ITEM 4.1 (a)

Issue/ Objection:
Car Parking

85 Harrington Street
The Rocks
GOLDEN AGE & HANNAS THE ROCKS

TITLE
**RESPONSE TO DoPE
ITEM 4.1 (a)**

For Information

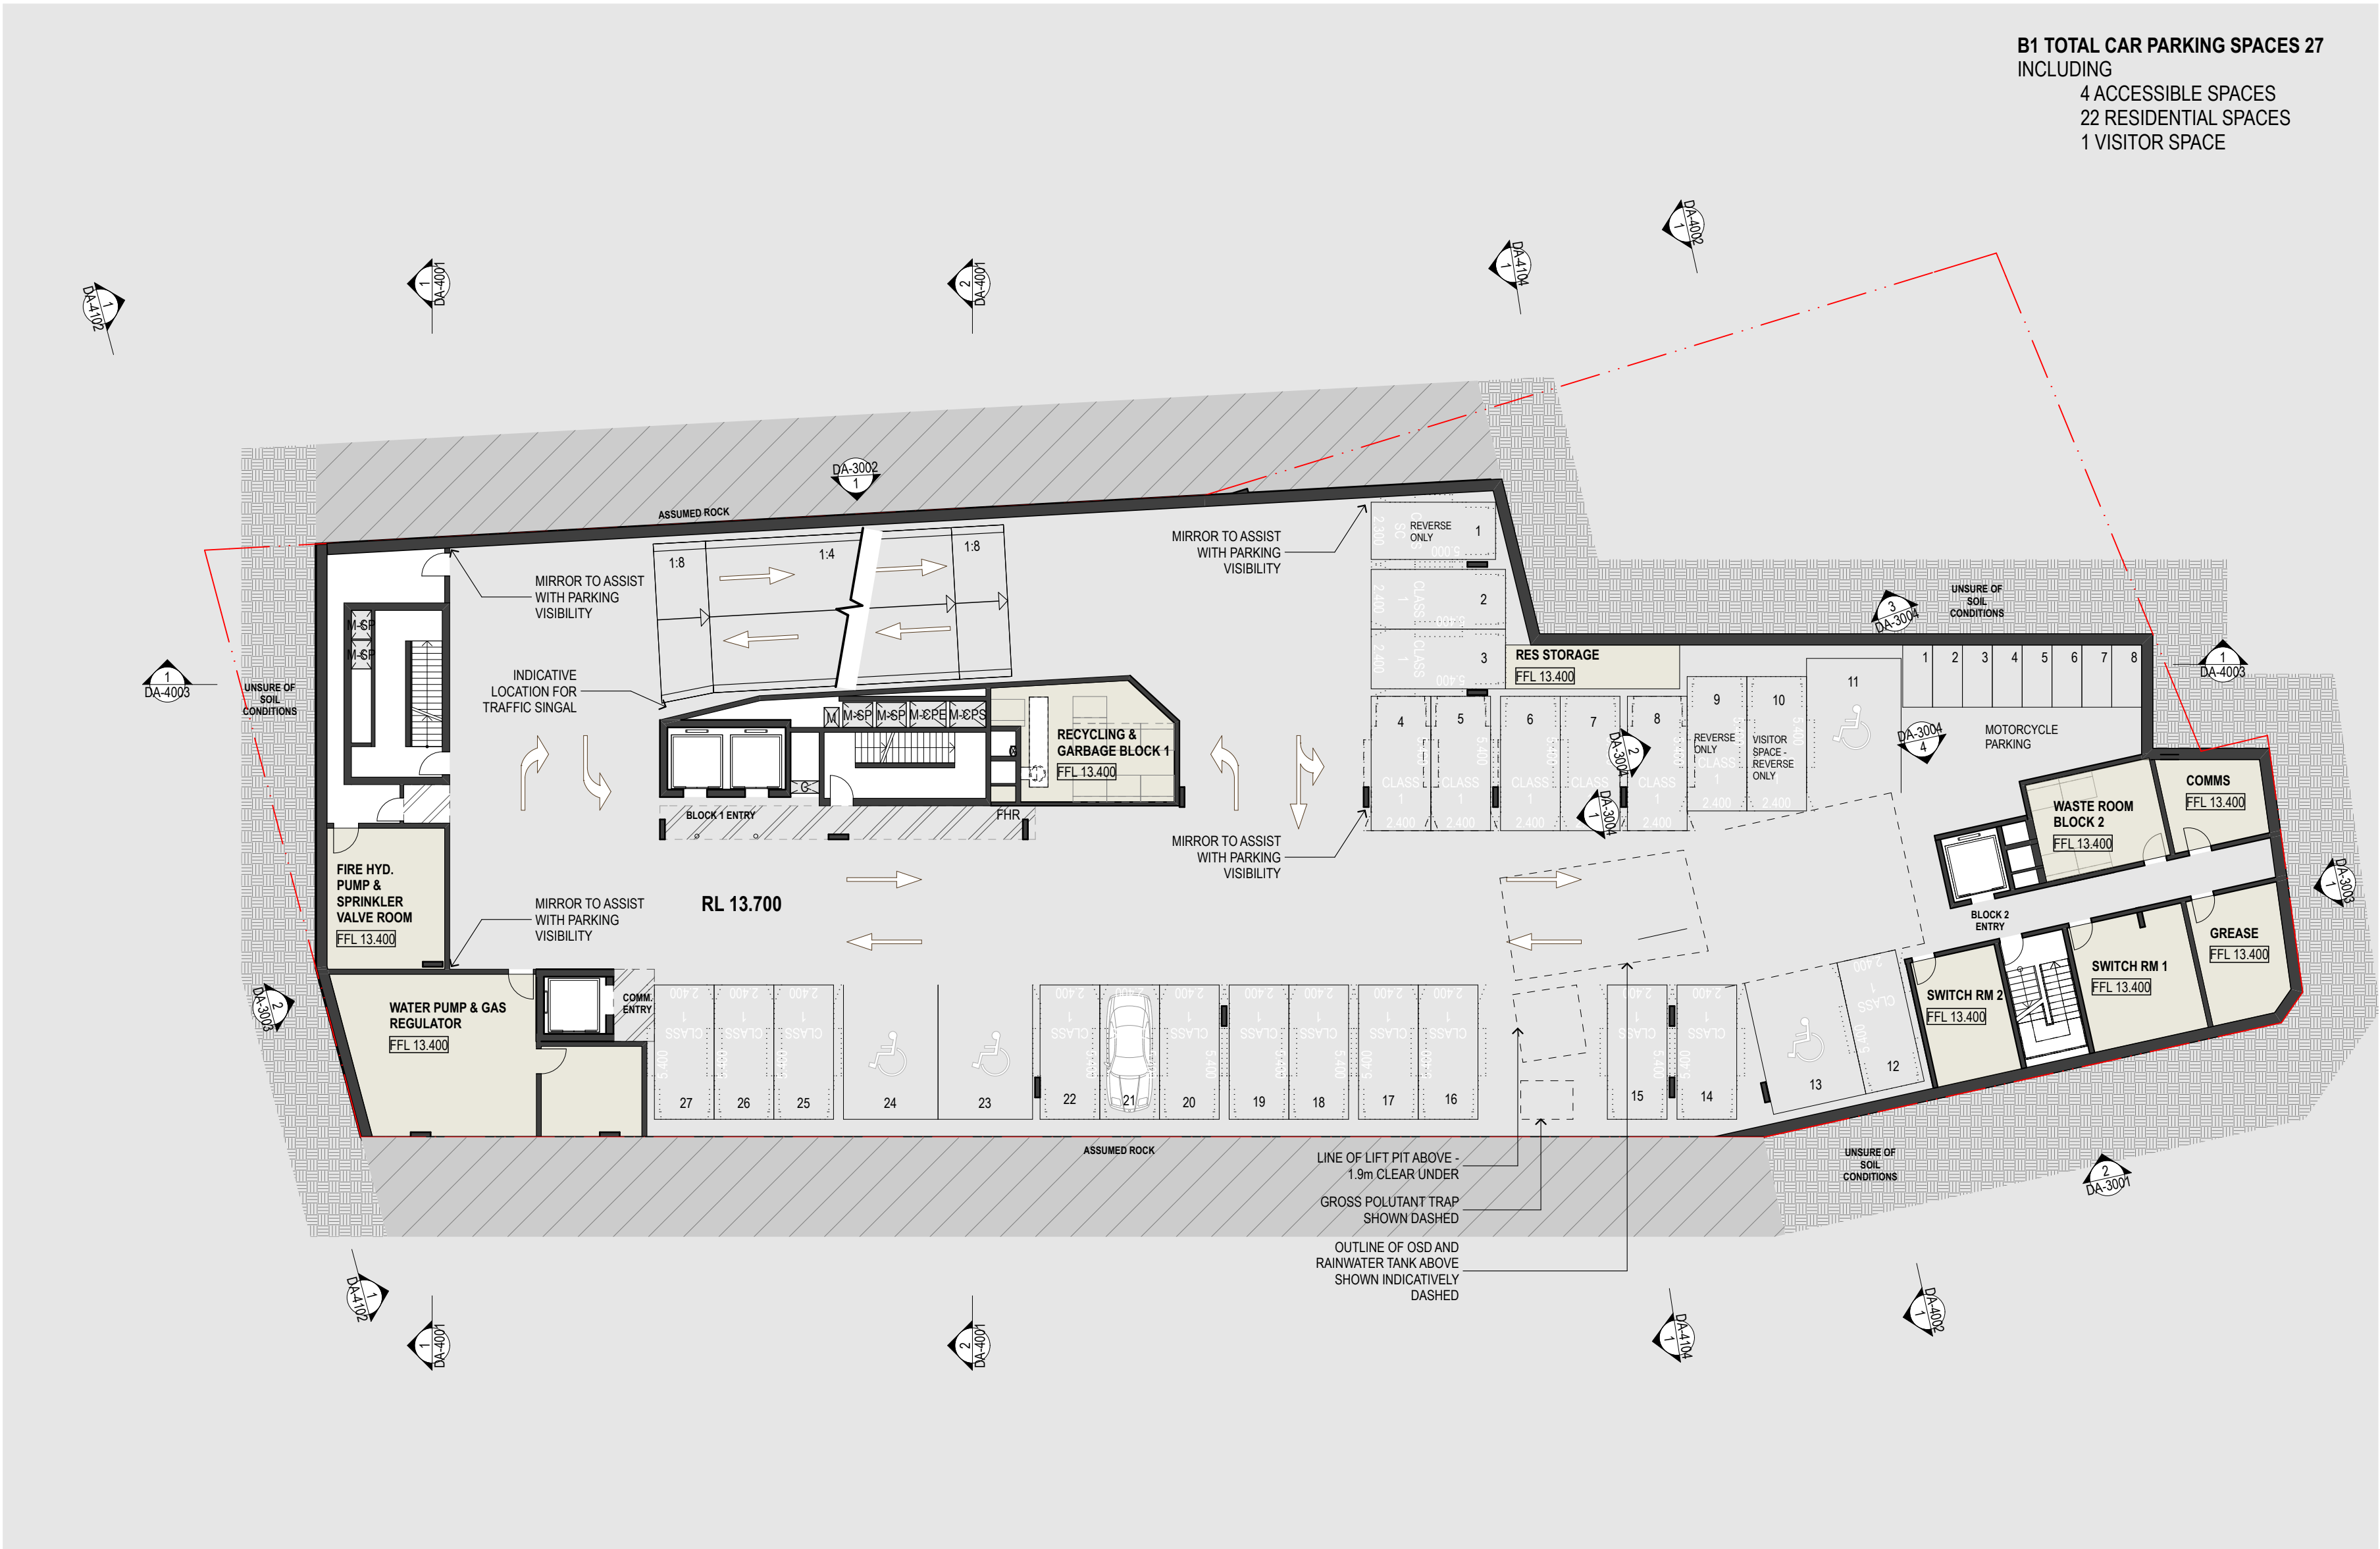
Description:
Given the location of the site within the CBD and close proximity to a variety of public transport nodes, consideration should be given to further rationalisation of the proposed number of residential car parking spaces.

Response
Refer to drawings and report provided by the traffic consultant.
